**KIRKLEES METROPOLITAN COUNCIL
INVESTMENT & REGENERATION SERVICE**

Reference No:	2023/62/91225/W
Site Address:	4, Broadgate Crescent, Almondbury, Huddersfield, HD5 8HT
Description:	Erection of rear extension with raised patio and alterations
Recommending Officer:	Tom Hunt

DECISION – CONDITIONAL FULL PERMISSION

Officer Report

PROPOSED BLOCK PLAN
SCALE 1:500

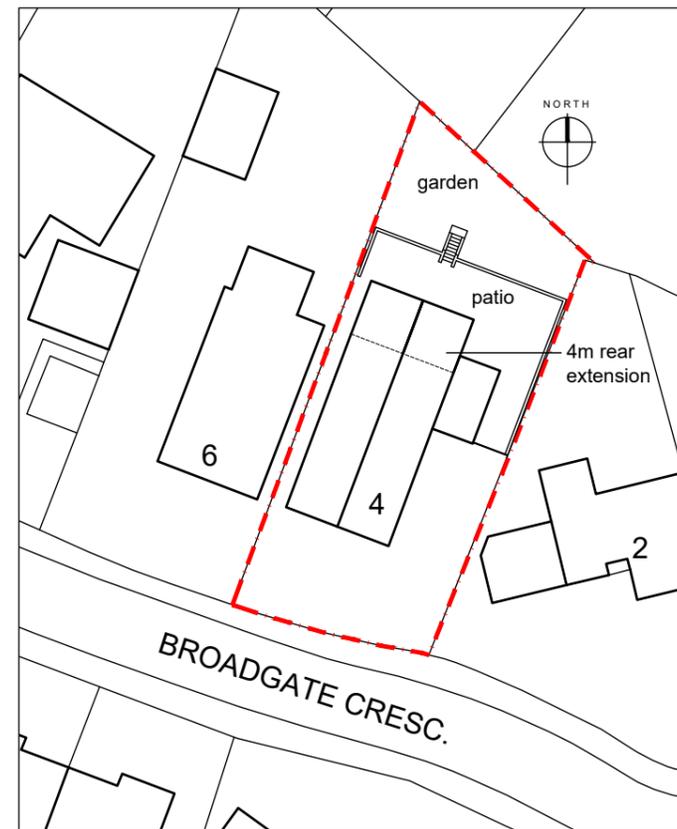
Officer Note: There is an indicated privet hedge to be planted on plans adjacent to No. 2. For the purpose of the assessment, this cannot be considered as part of the application as the height and retention of the hedge cannot be controlled by planning condition for the purposes of privacy.

Drawn by <b>RH</b>	Date <b>APR 23</b>	App'd <b>-</b>
Drawing no <b>AL 02</b>	Project no <b>21-0142</b>	Scale @ A3 <b>A.S.</b>
		Rev <b>D</b>

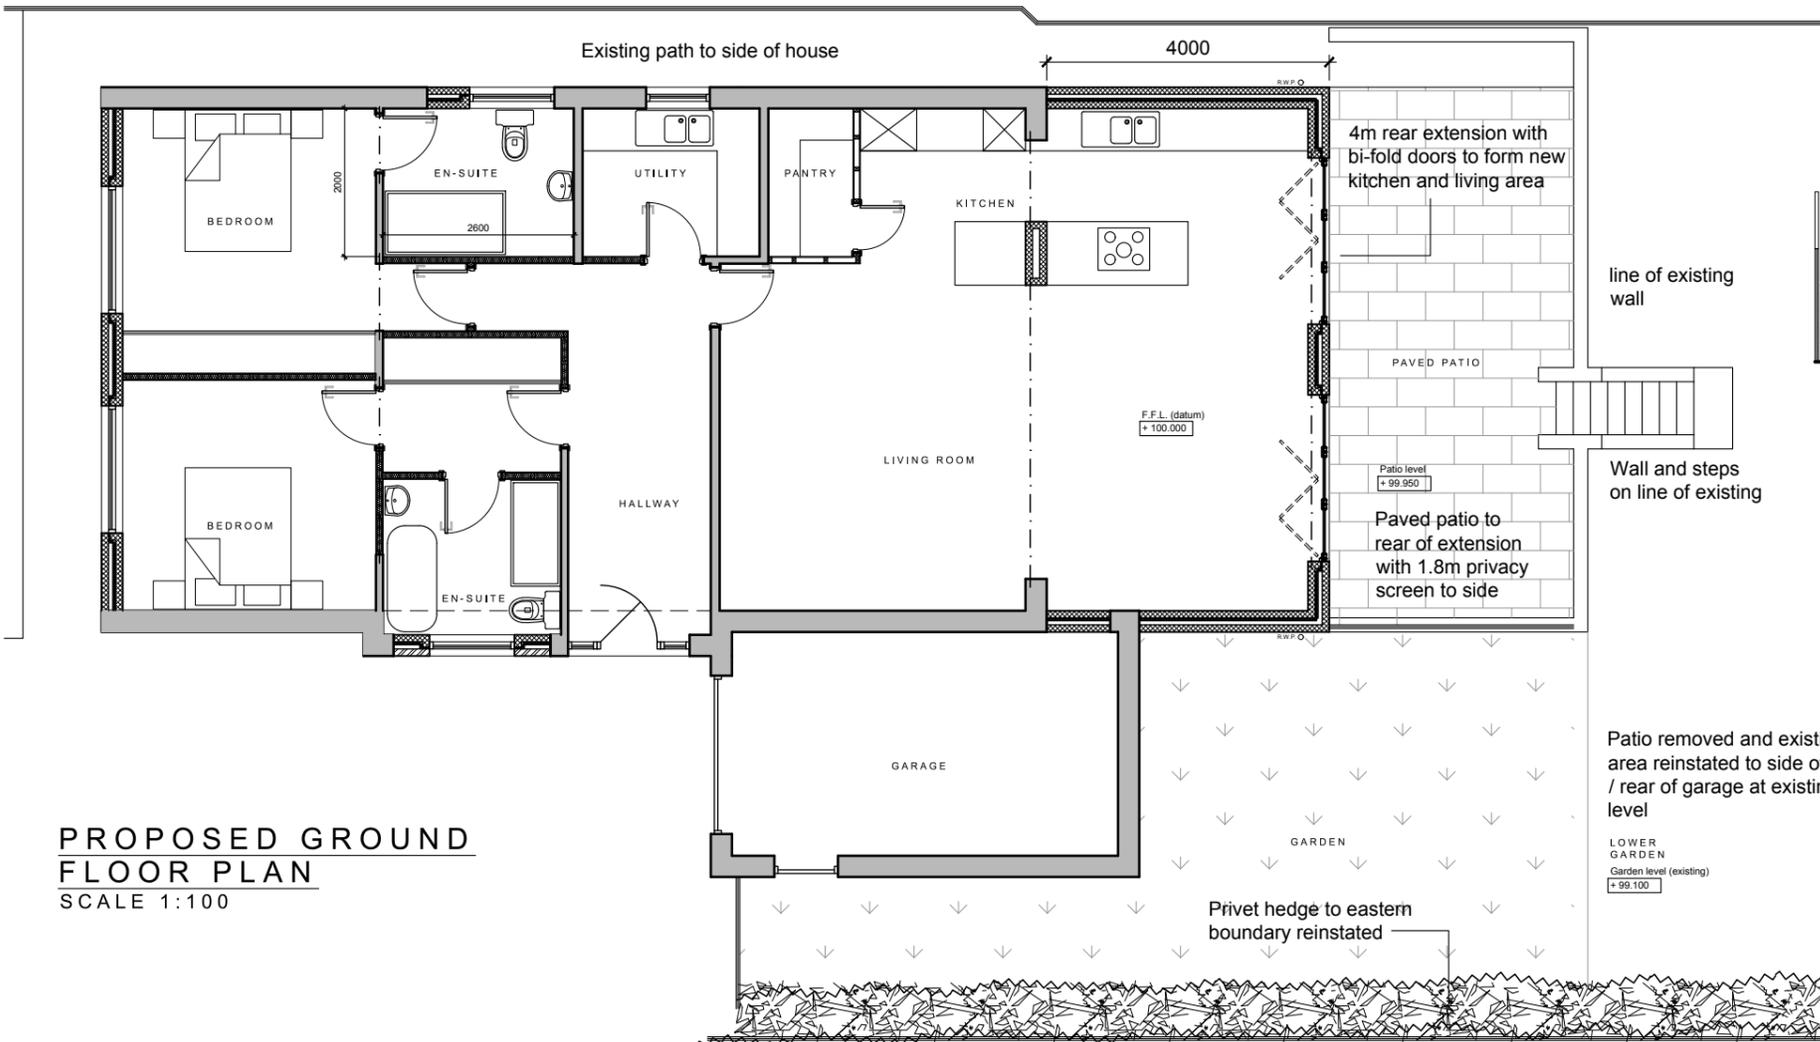
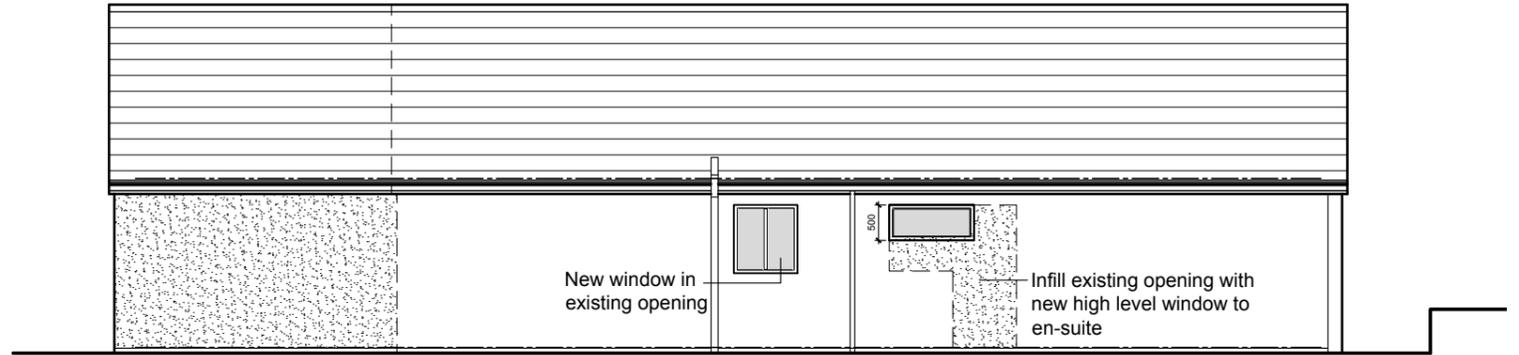
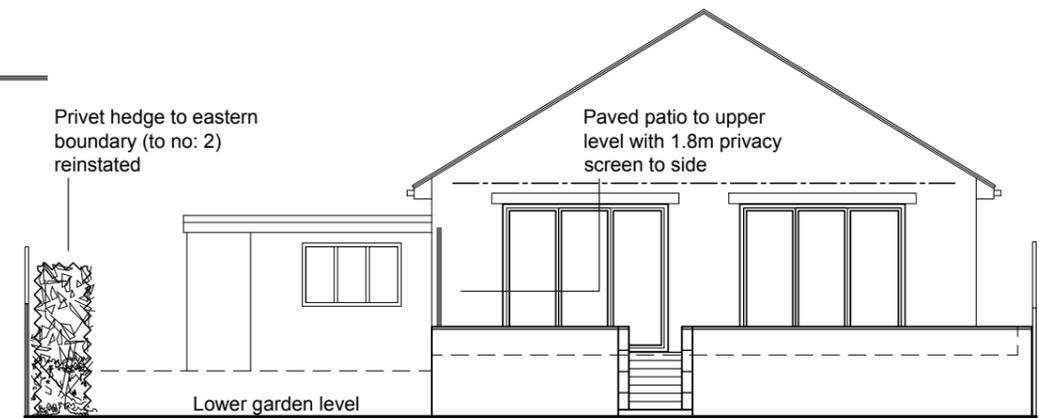
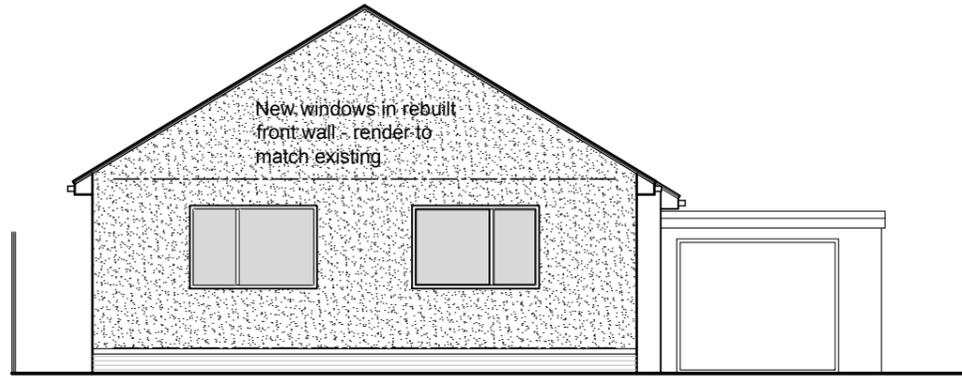
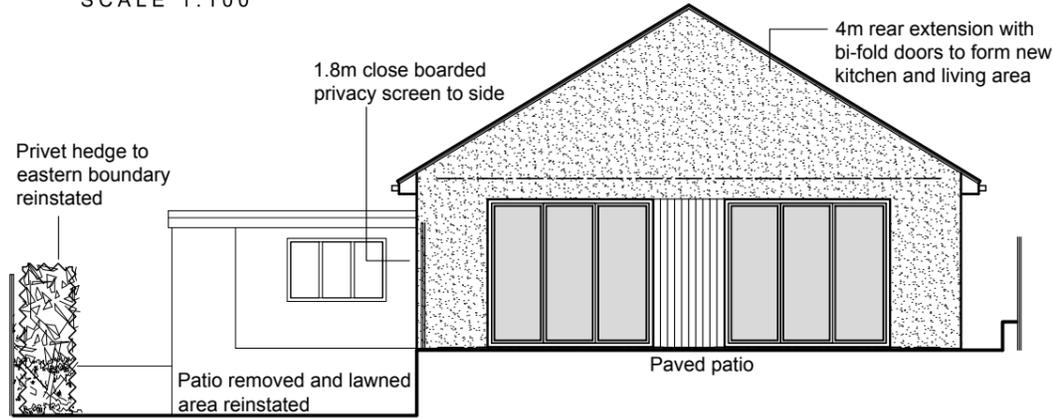
The neighbour has a garden tapering to the rear with a rear conservatory and a timber fence with trellis on top. This would be moderately close to the maximum permitted height of 2m from their ground level. The patio would have a raised floor level set back from the boundary by ~5.7m and would have a 1.8m height privacy screen preventing views from the patio to this neighbour; this screen can be conditioned to ensure privacy is retained satisfactorily.

5. The 1.8m high solid, and/or obscure glazed, privacy screens (to grade 4 level of obscurity) as shown on the hereby approved elevation and floor plan no. AL 02. rev D shall be installed to the east boundary of the raised patio area as shown on that plan, within three months of the date of this permission. The 1.8m high solid and/or obscure glazed privacy screen shall thereafter be retained.
